DECISION DELEGATED TO DEVELOPMENT MANAGER

Application No: H14-0589-20 **Applicant:** Lunns Haulage Ltd.

Proposal: Details relating to acoustic fence along northern boundary (Condition 6 of H14-0106-20)

Location: Rosecott Farm Dozens Bank West Pinchbeck

LANDSCAPING, TREE PLANTING & FENCING SCHEME.

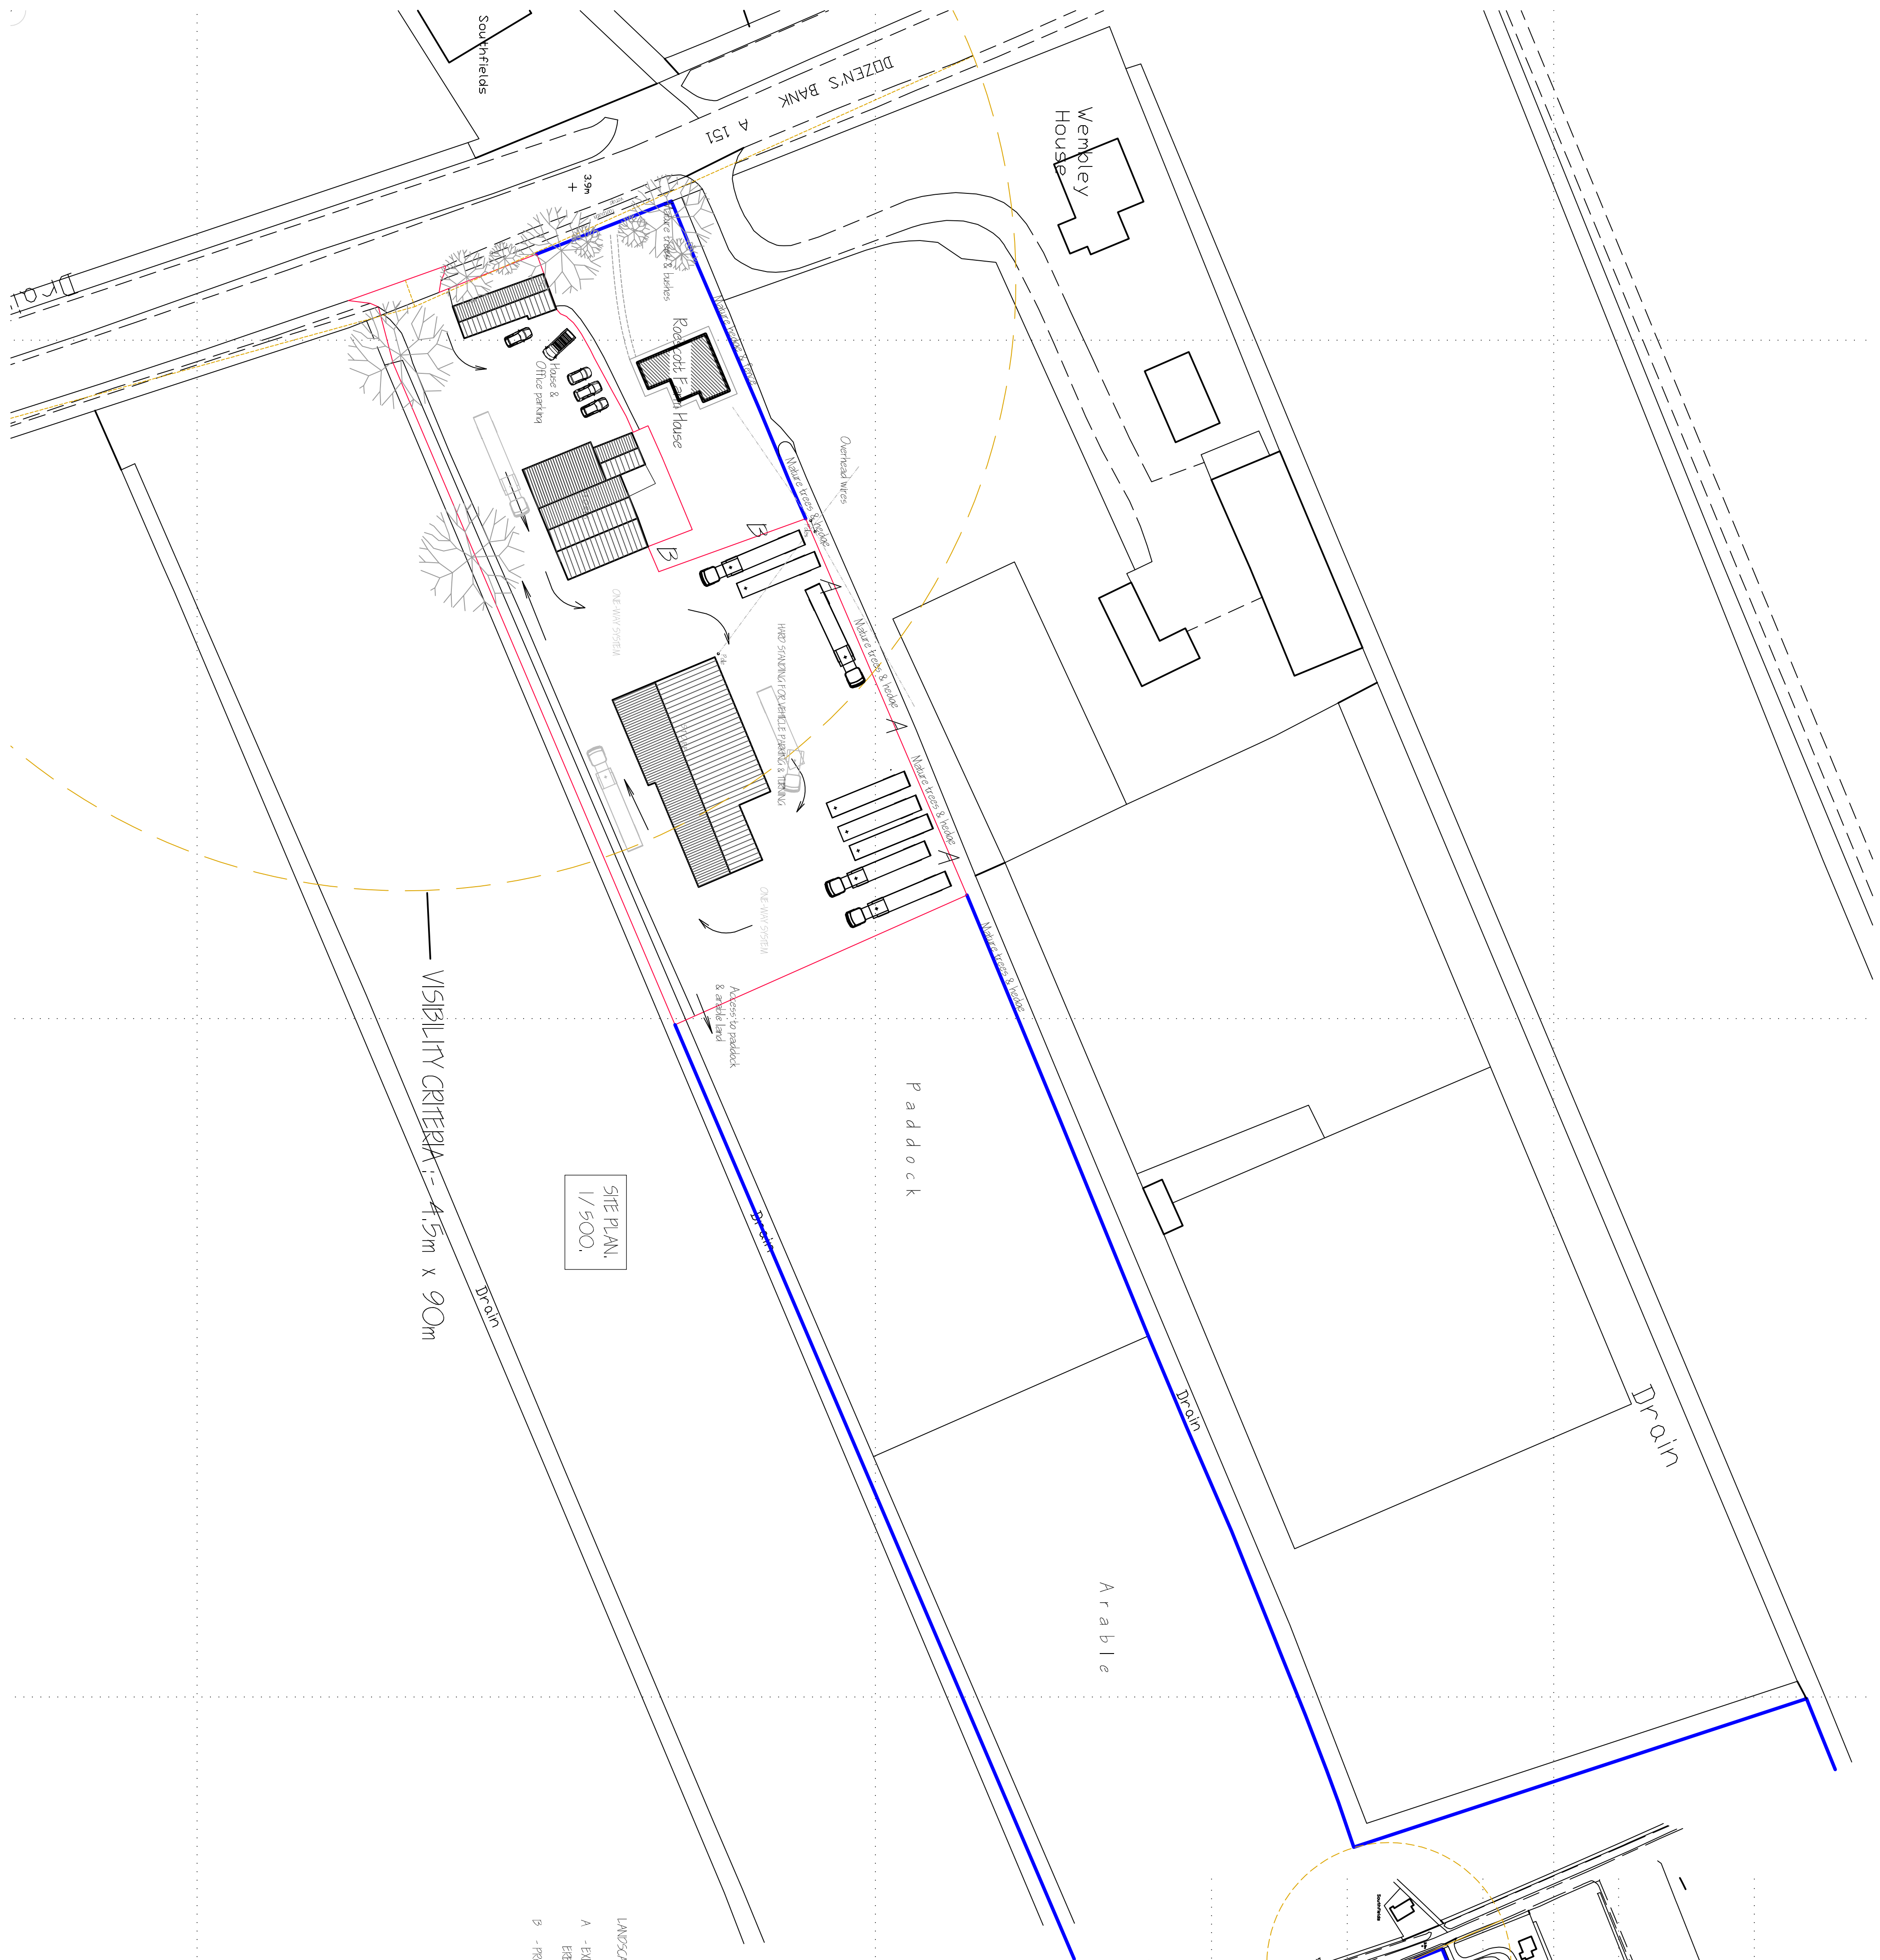
Proposal does not accord with Condition 6 of H14-0106-20
Fence should be a minimum of 2.5 metres in height.
Fence should be a minimum of 25kg per metre squared.

The height of the proposed acoustic fencing was not specified in Condition 6. The submitted details are for a 1.8m high fence.

A standard density for acoustic fencing is 10kg per metre squared. It is considered that 25kg would incur extra costs for the applicant for what would likely be a minimal difference in noise reduction.

The site slopes gently away from the A151 and then plateaus before reaching the acoustic fence location. Due to the flat nature of the proposal site there is not considered to be a need to raise the height of the fence above the proposed height of 1.8 metres.

It is considered the submitted fencing would adequately mitigate noise from the approved haulage use and Condition 6 of H14-0106-20 should now be discharged.
